**Subject: 185 Fore Street
Final Level III Site Plan and Subdivision Application
Letter of Response #3**

On behalf of Bateman Partners, LLC, we are pleased to provide the following responses to the Review Comments related to the Final Subdivision and Site Plan Application for the proposed mixed-use building at 185 Fore Street. For ease of reference we have repeated the comments in *italics*, followed by our response.

COMMENTS FROM DAVID SENUS, WOODARD & CURRAN DATED 02-26-15

E1.01

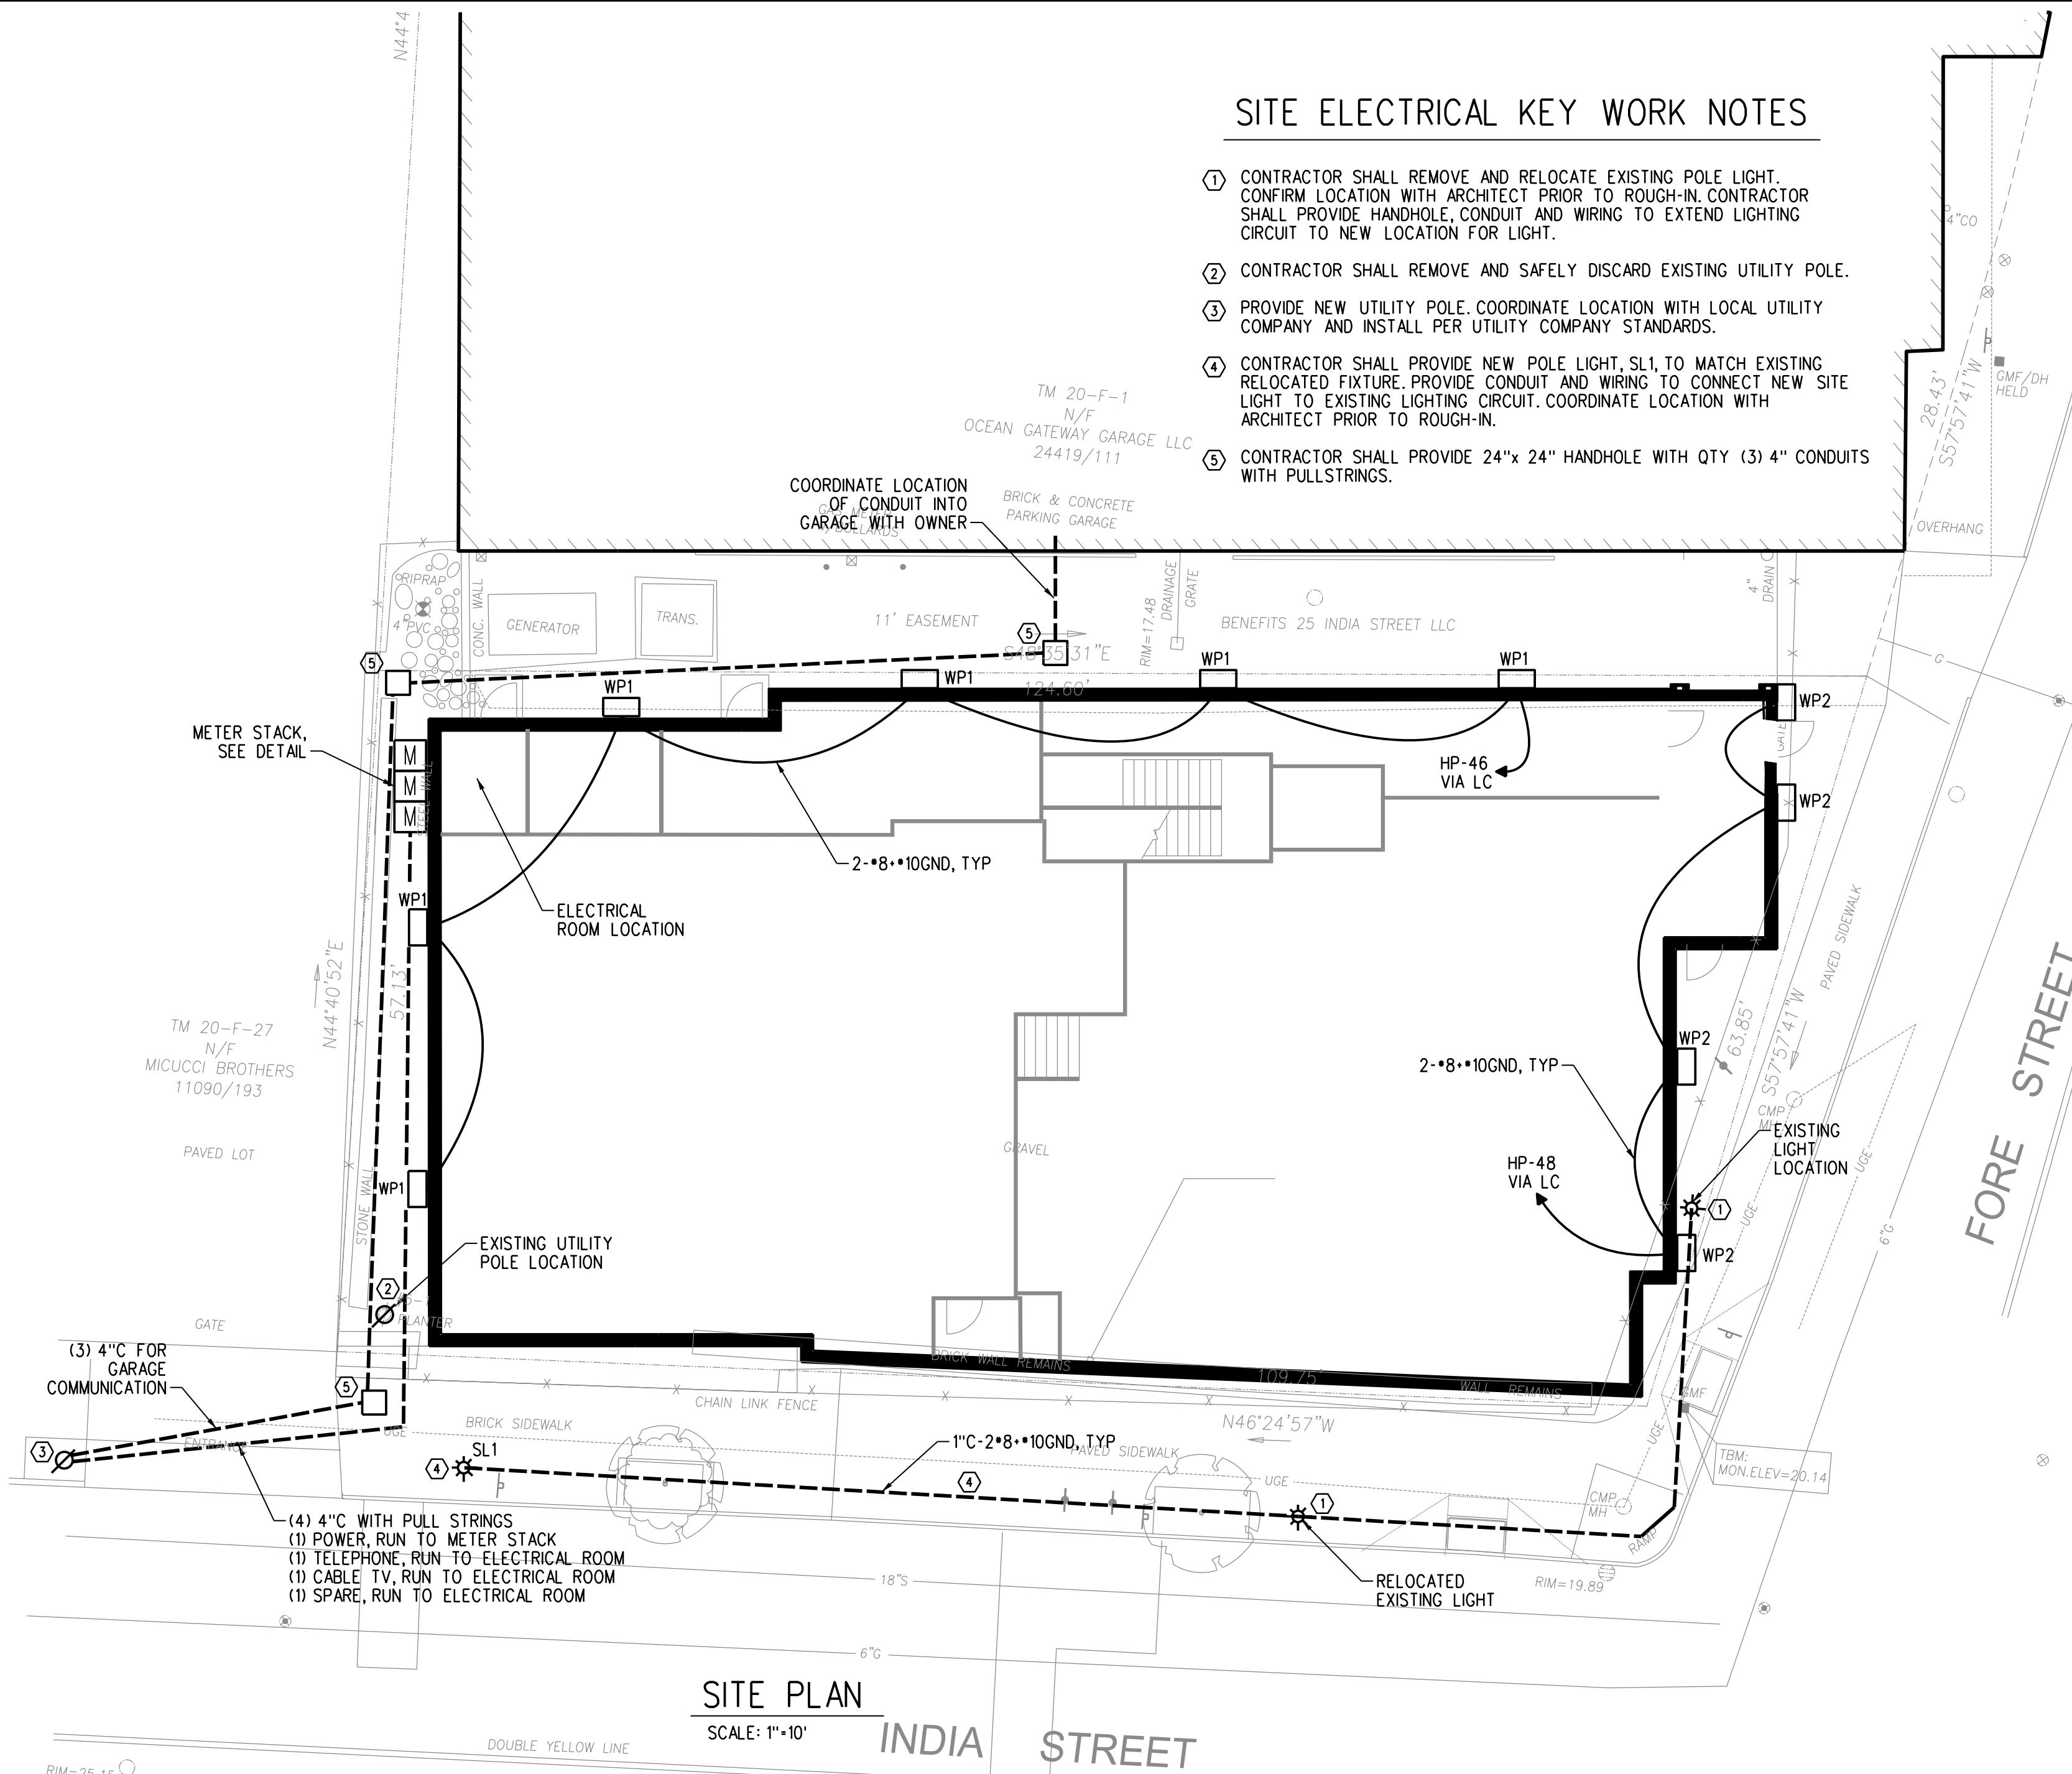
Sheet E1.01 shows an eight inch roof connection to the 18" sewer in the street. Sheet C4.0 shows this connection into a catchbasin. Please delete connection on Sheet E1.01.

Sheet E1.01 has been revised as requested. The revised sheet is included in the attached plan set.
